ADDENDUM.

Proposed Front Elevation

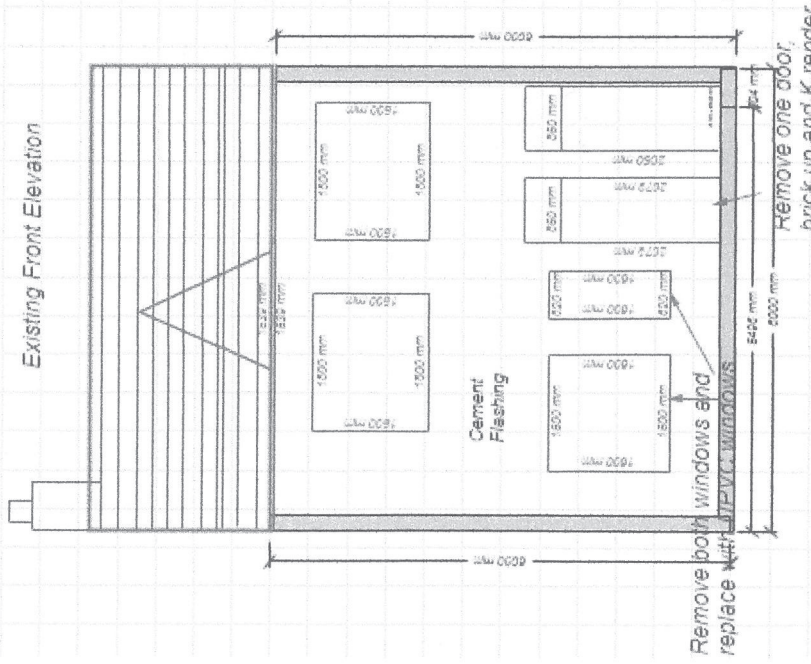
Re change of windows to front as of ref no 97/00155/FUL 1997 will use existing lintel after being checked by L.A. When purchased property rear yard was partially covered over, with a roof re 01/00041/FUL 2001 but in disrepair with panelling and door lying loose, removed partial of roof and framing and replaced remaining roof covering with temporary felt and added velux windows. Roof and velux windows to be covered with epdm roof covering to finish. Bifold doors added as re plans.
